Planning Application No: 3/2026/0467
Grid Ref: 367926 438012

Proposal: Proposed dormer loft conversion to include the extension of the existing flat roof dormer to the rear, alteration of the existing front dormer to a pitched roof, additional pitched roof dormer to the front elevation, installation of conservation rooflights, alterations to external window and door positions including a Juliet balcony and associated internal alterations.

Location: Shire Croft Shire Lane Hurst Green BB7 9QR

PROPOSED SITE PLAN
(As Existing)
Scale 1:200

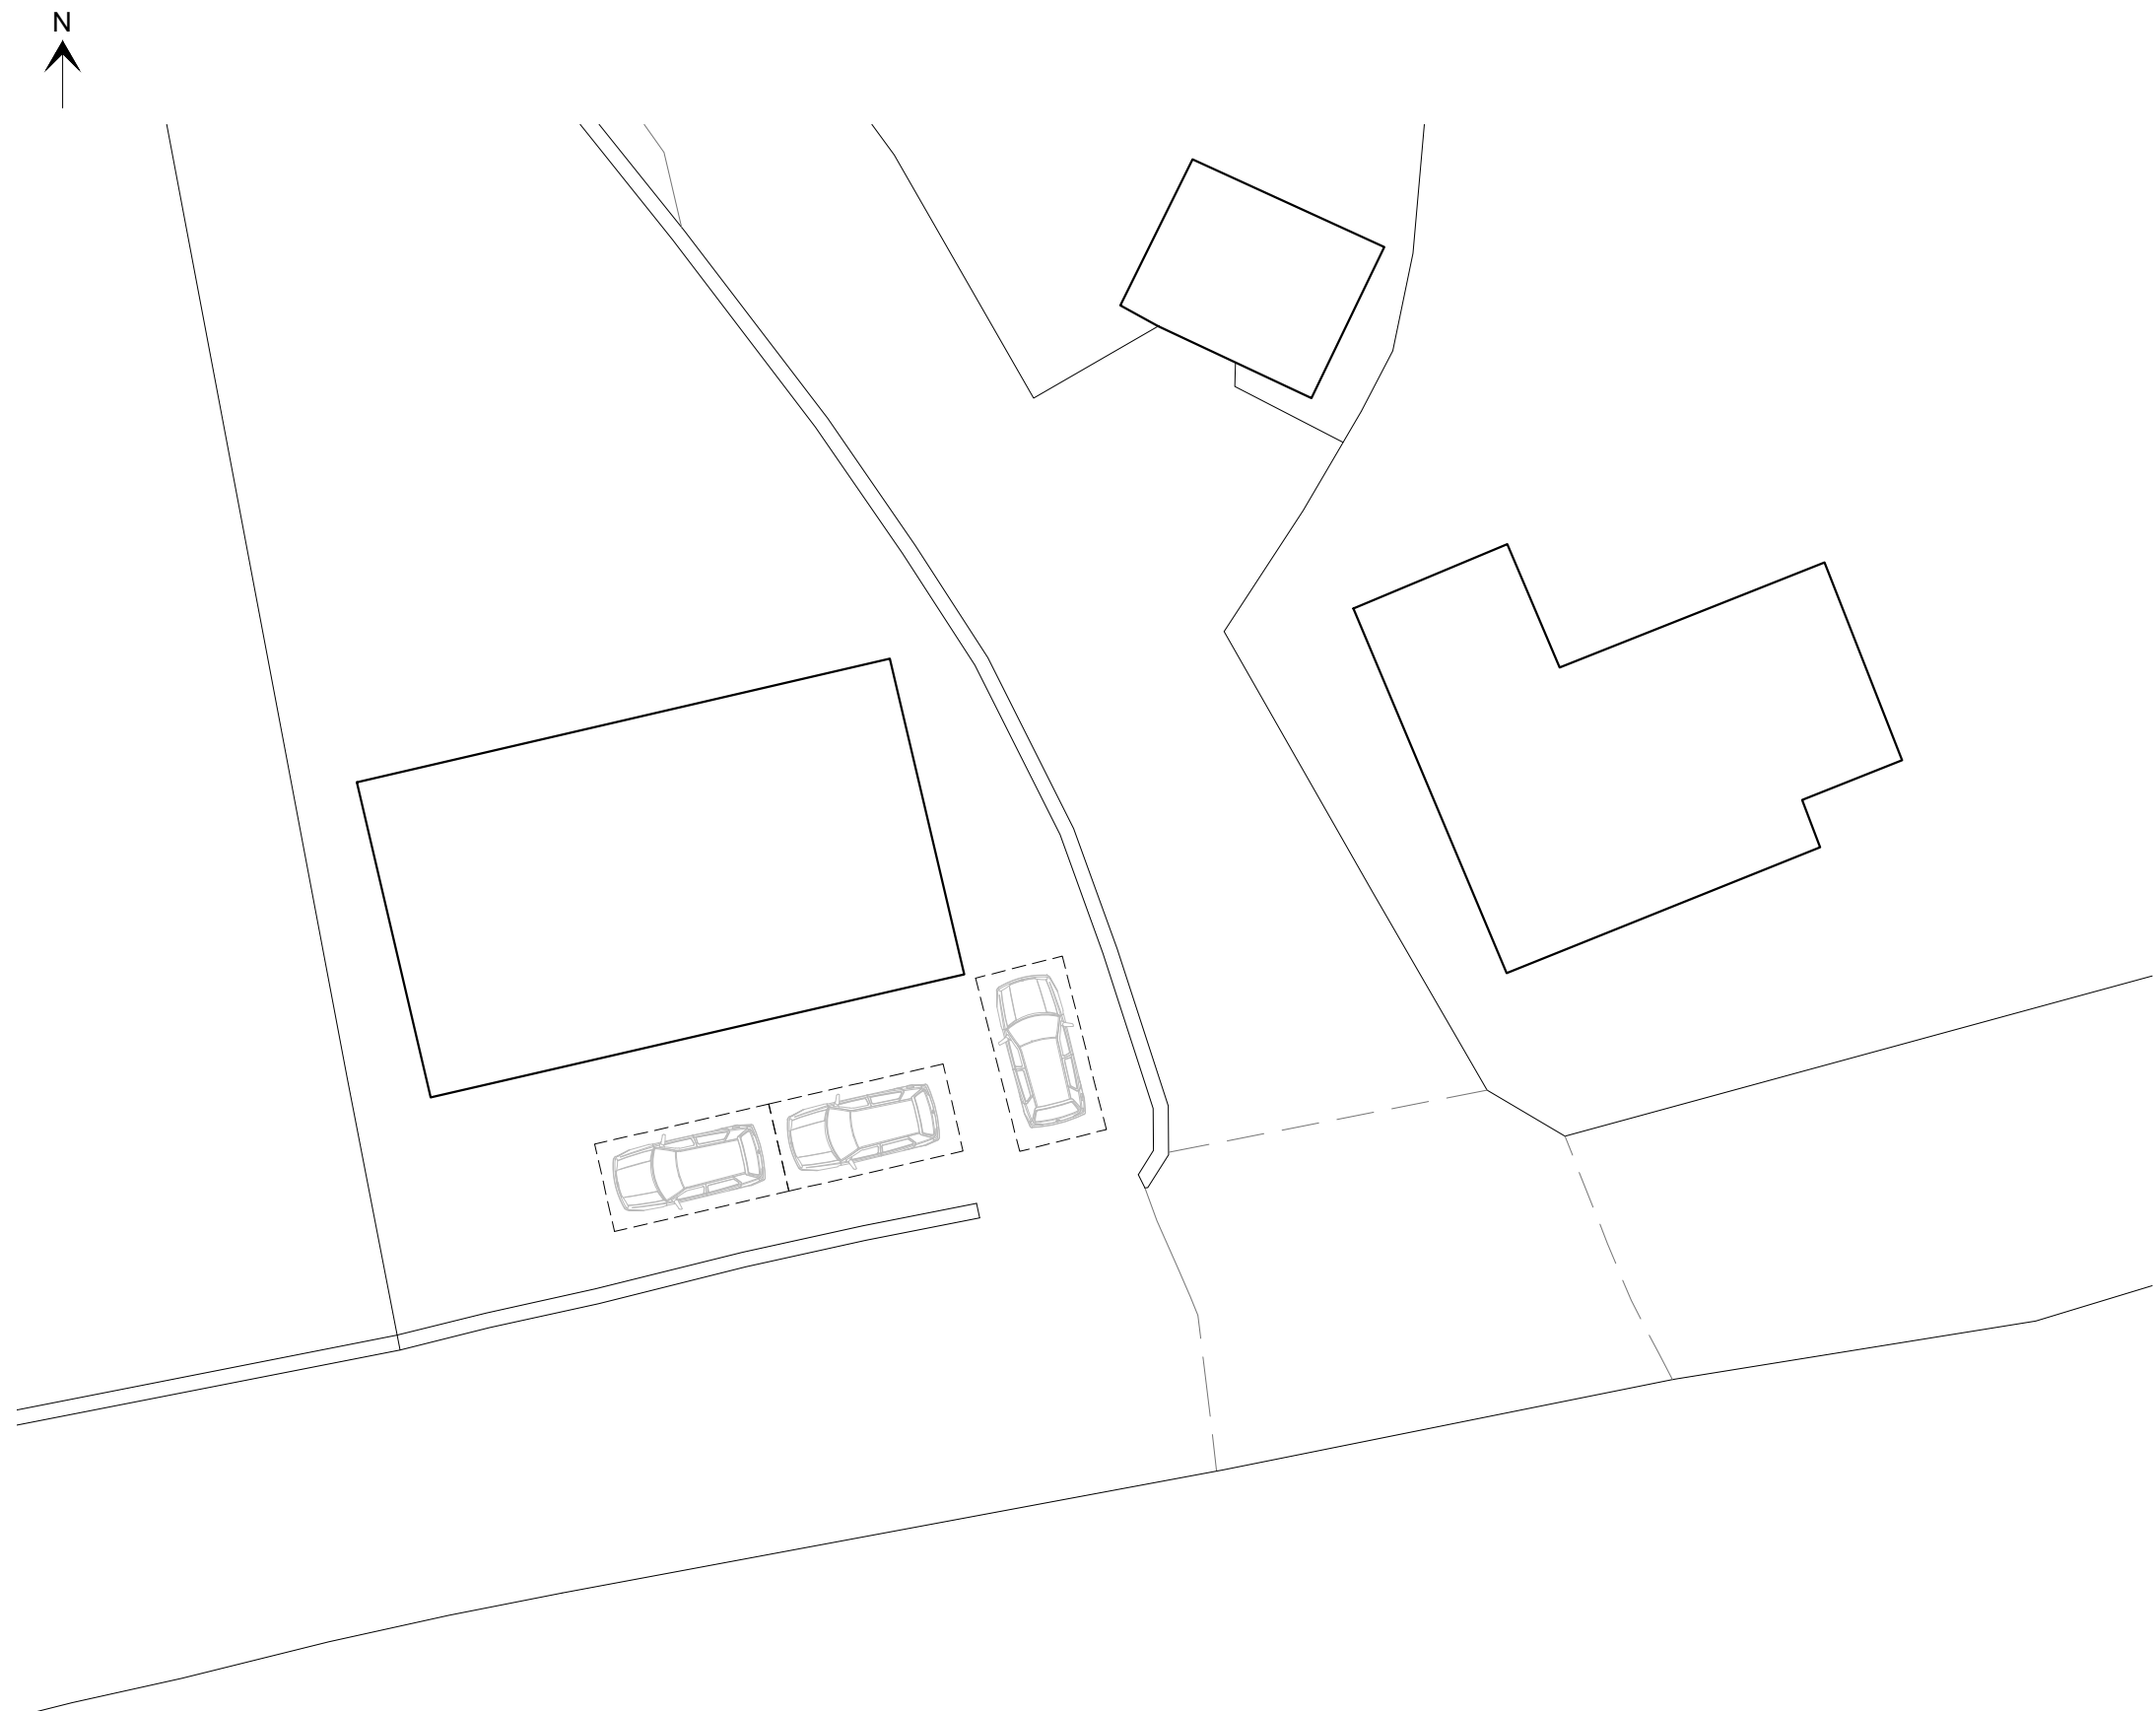
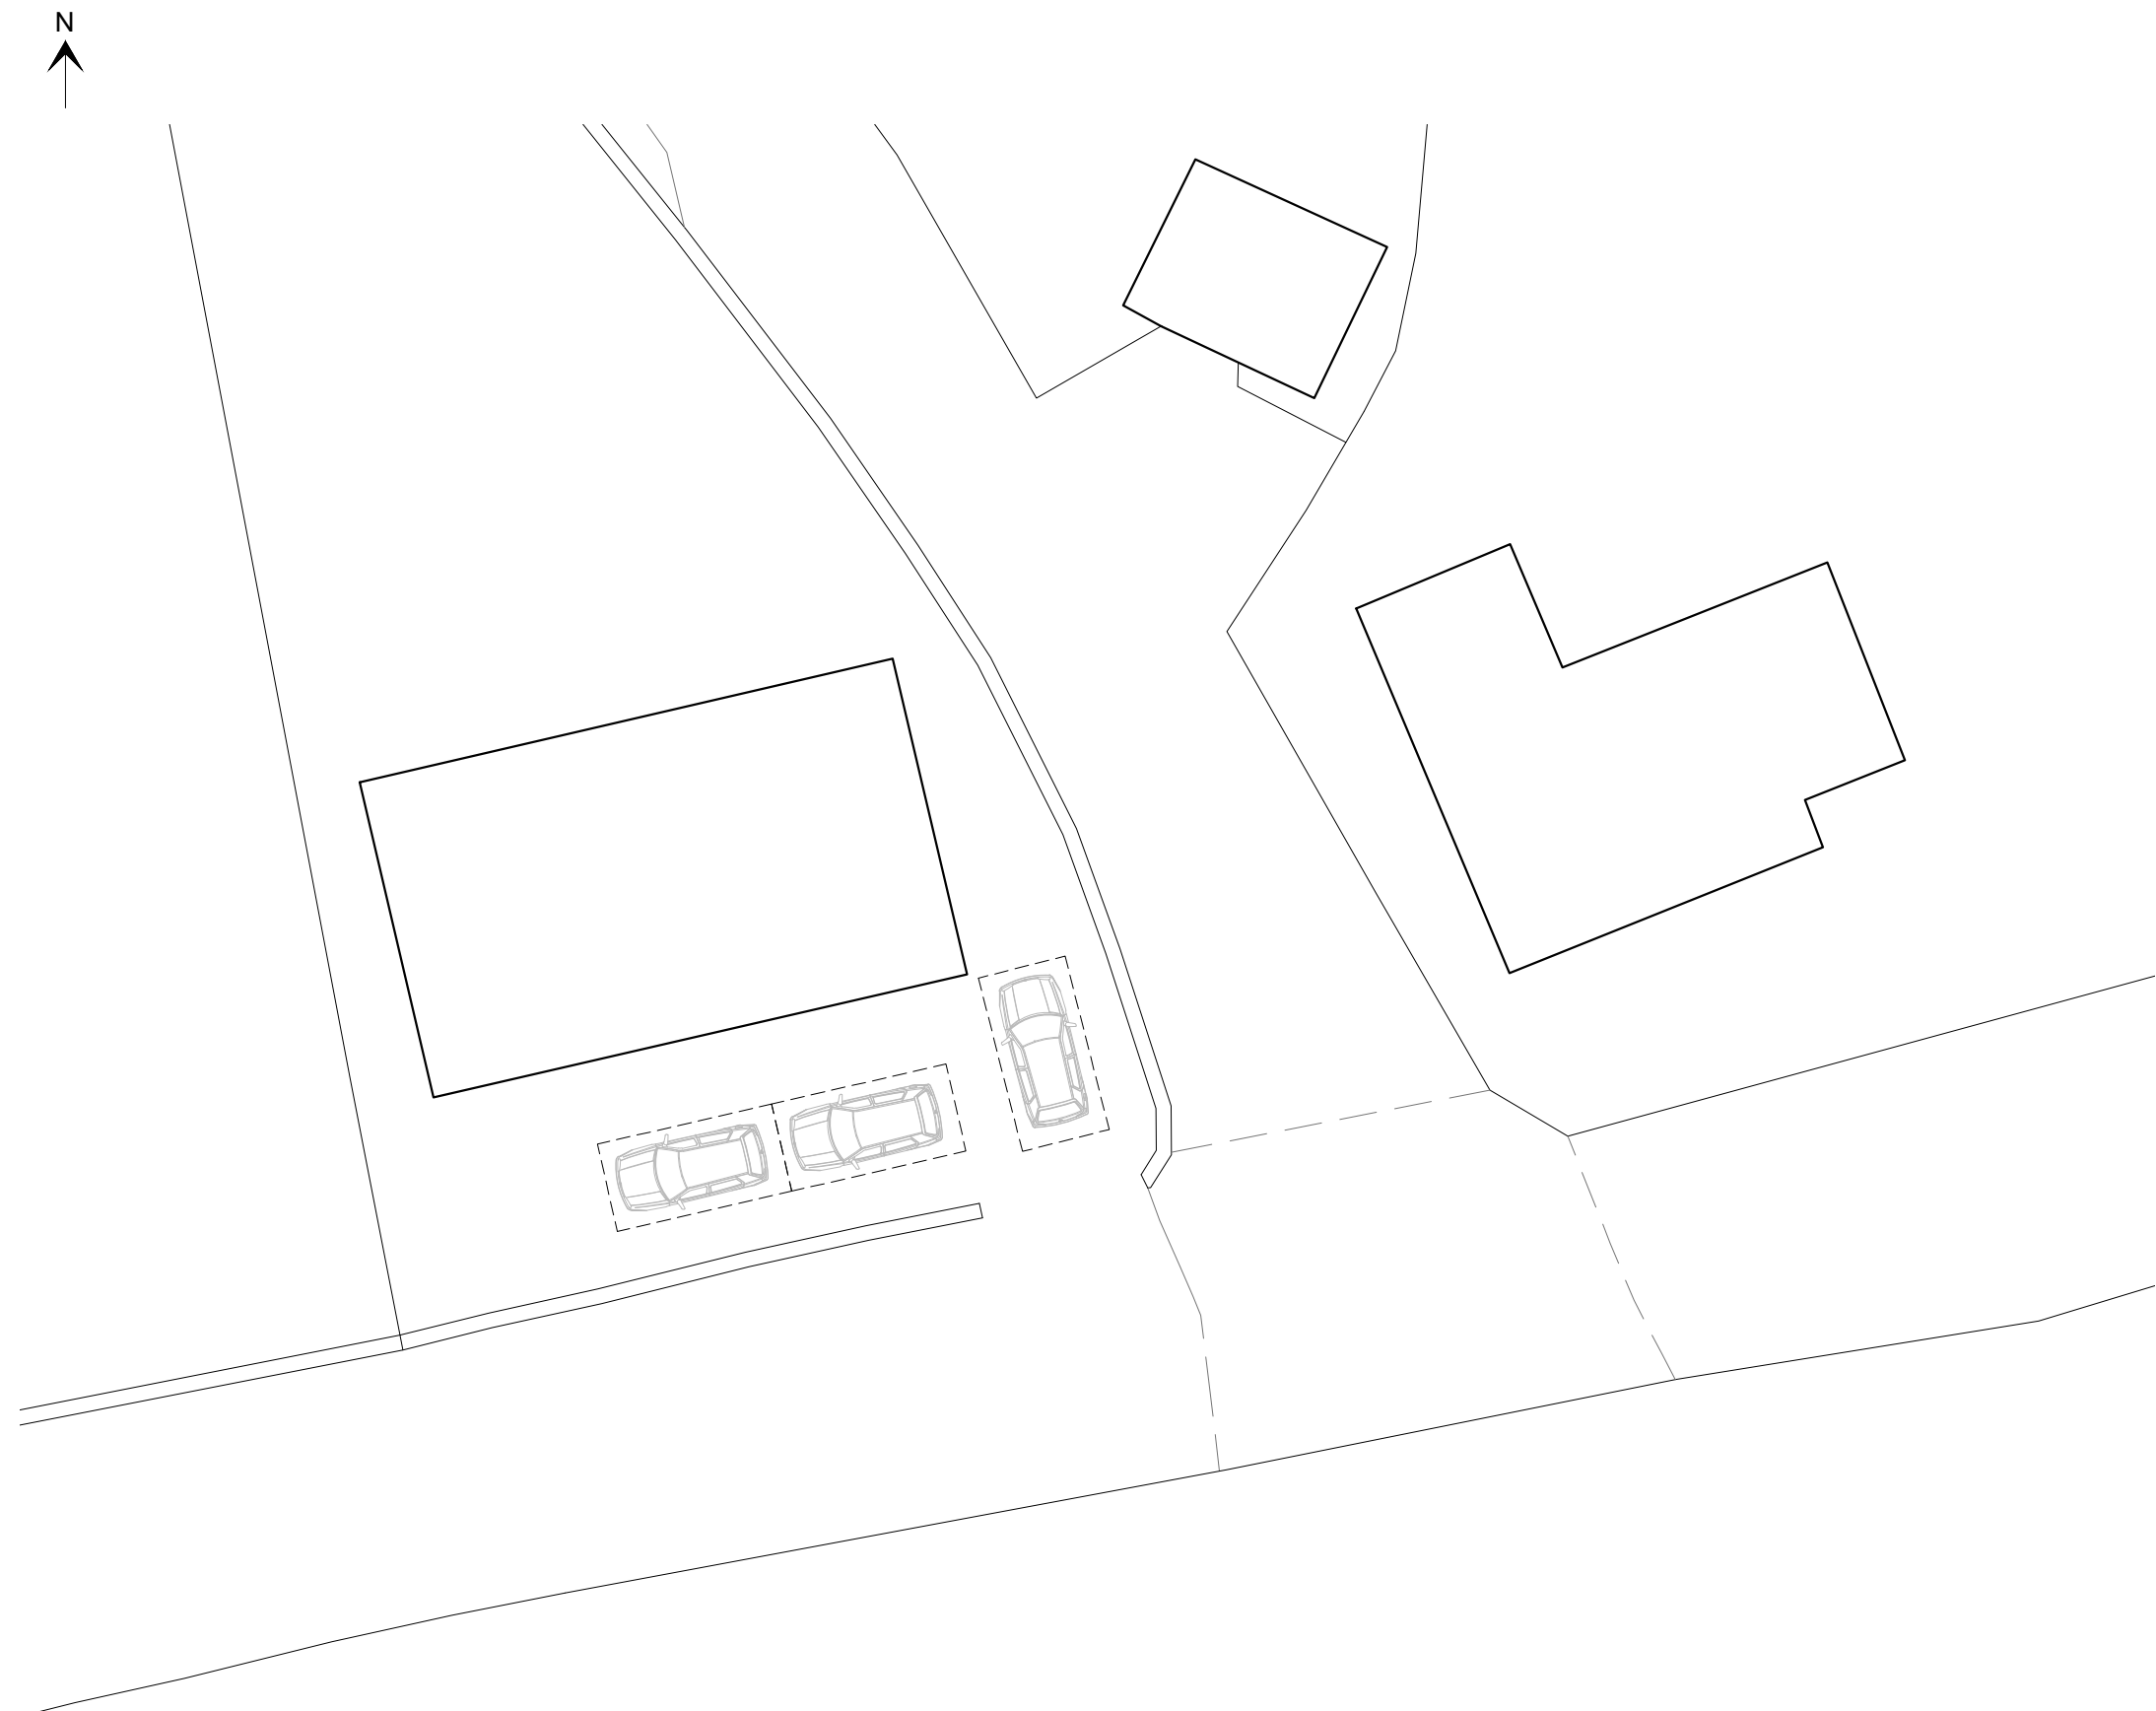
With ref. Planning statement submitted (3) Image 2 Proposed First Floor Plan – 4 bedrooms, (6.4) Highways (facilitates the required parking spaces for 4 bedrooms....), the existing parking arrangements are not affected with this proposal, and the parking spaces remain as existing, which meet parking standards requirements of 3 parking spaces.

No reduction to the existing parking spaces and no increase in number of bedrooms, no objection to the proposal subject to the following conditions.

- The parking (and manoeuvring) area shall thereafter always remain available for parking of vehicles associated with the dwelling. Driveways/vehicle parking areas must be properly consolidated and surfaced in bound porous materials, (not loose stone, gravel or grasscrete) and subsequently maintained in good working order at all times thereafter for the lifetime of the development. Reason: To ensure satisfactory levels of appropriately constructed off-street parking are achieved within the development and to avoid unnecessary parking on the highway to the detriment of highway safety.
